BENT GRASS EAST COMMERCIAL
11659 BENT GRASS MARKET VIEW
EL PASO COUNTY, CO
DEVELOPMENT PLAN

COVER SHEET

V1 Comment:
County

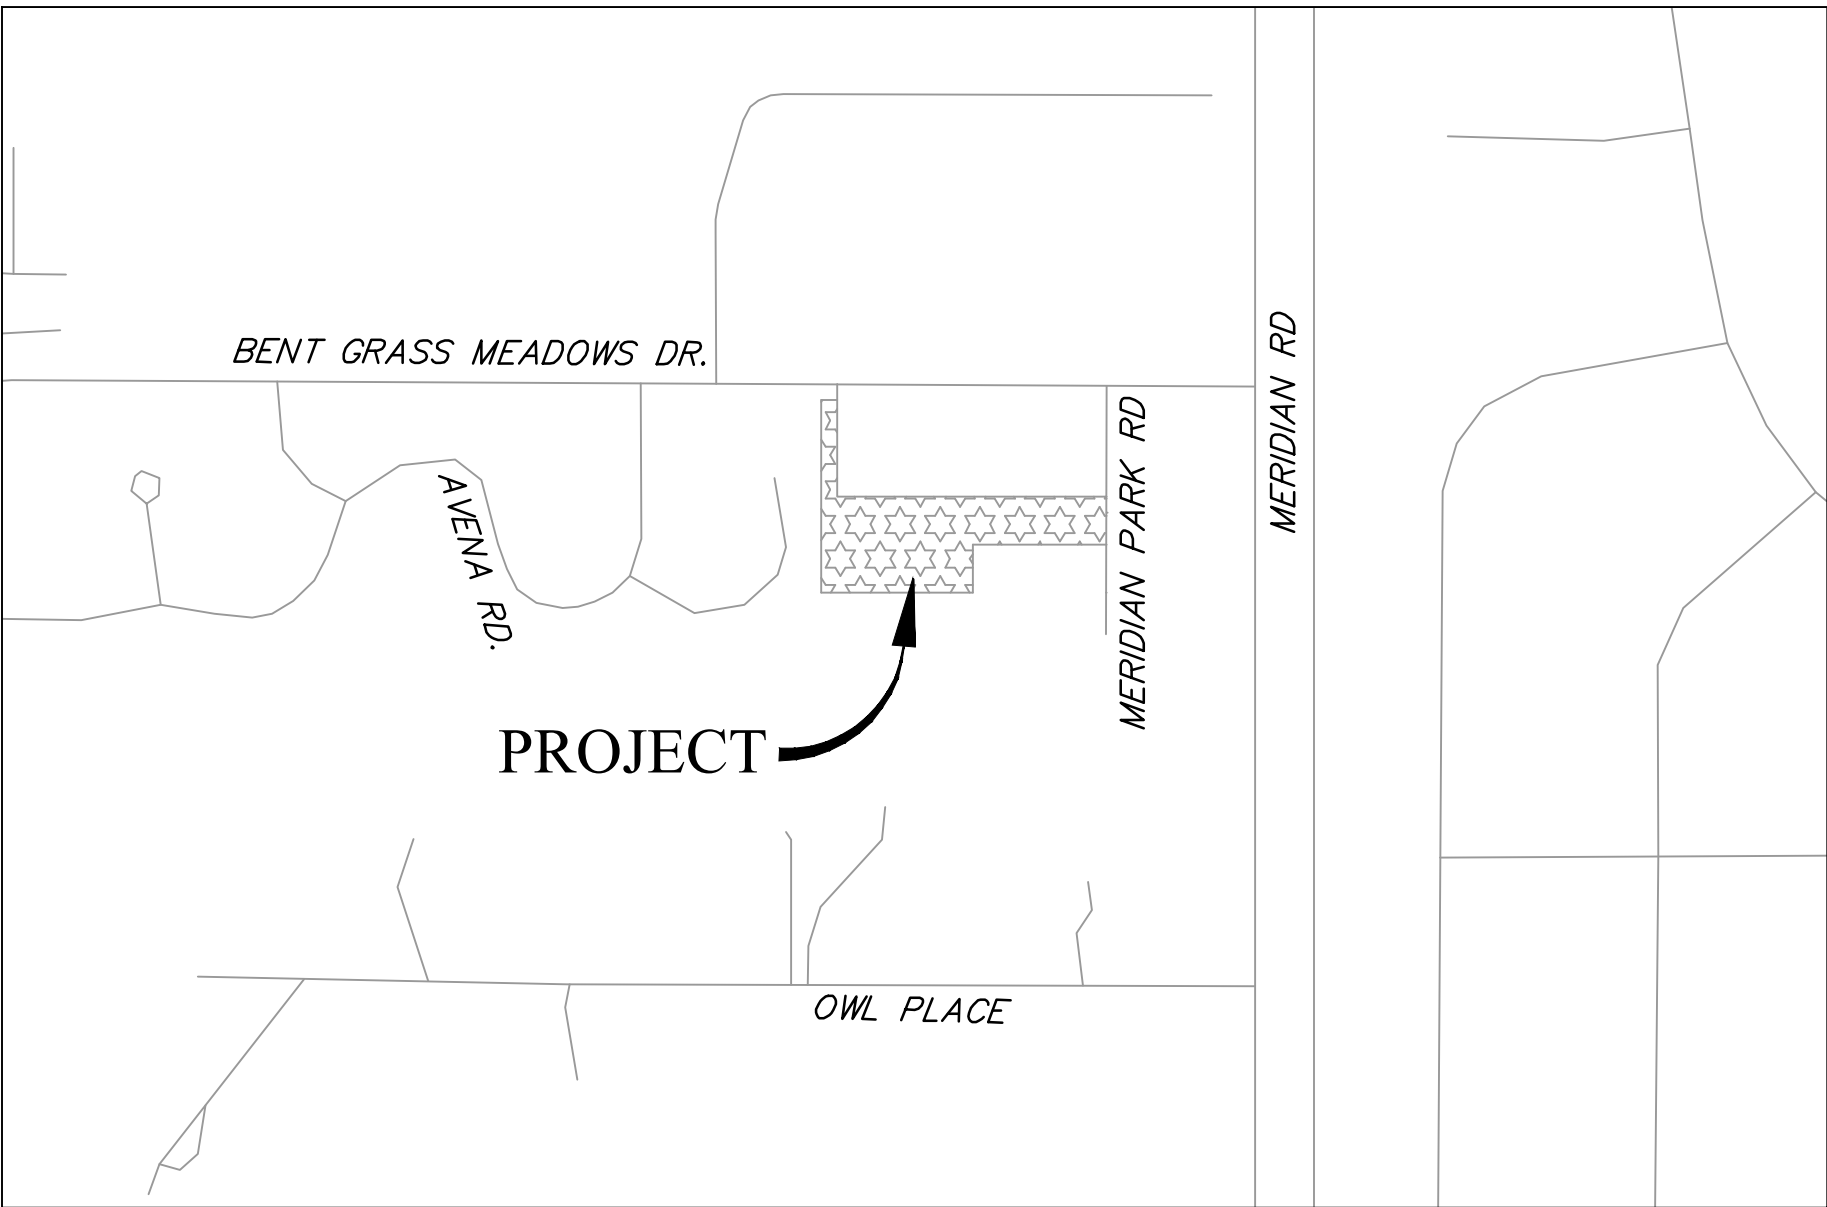
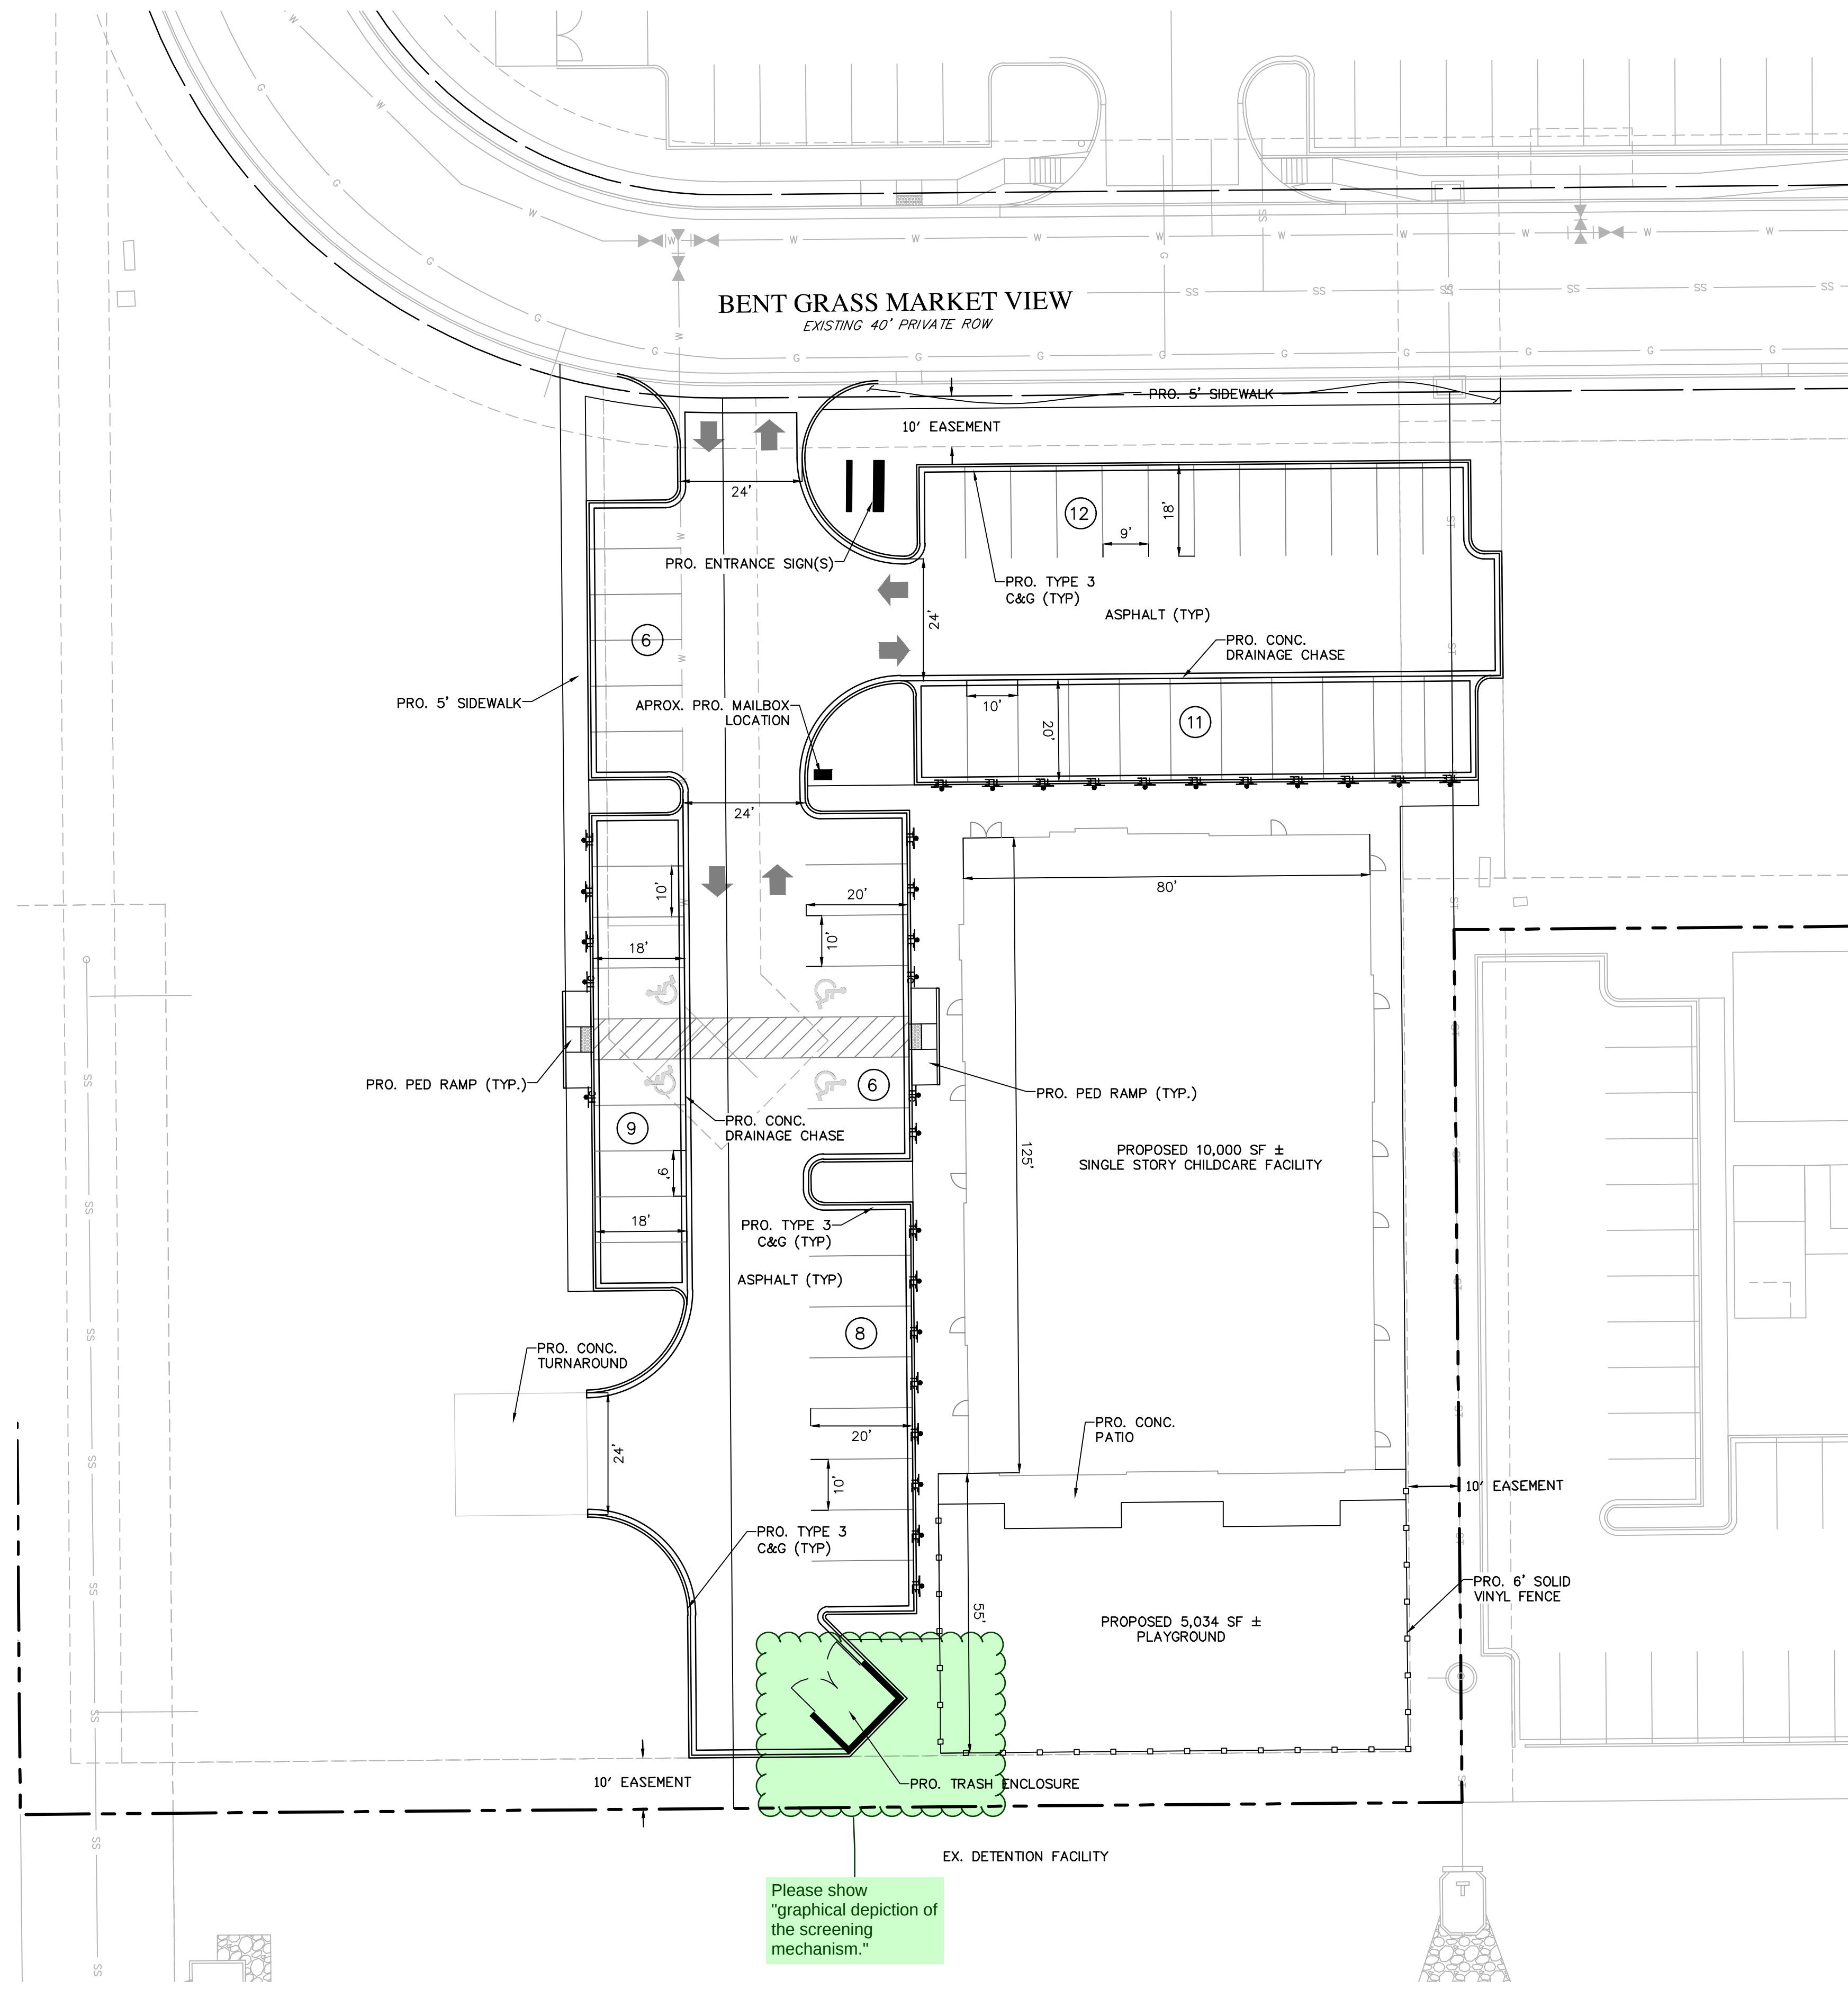
V1 Comment:
County; please be
specific.

V1 Comment:

Please add:

PCD File No. PPR2625

V1 Comment:
Please show
"graphical depiction of
the screening
mechanism."
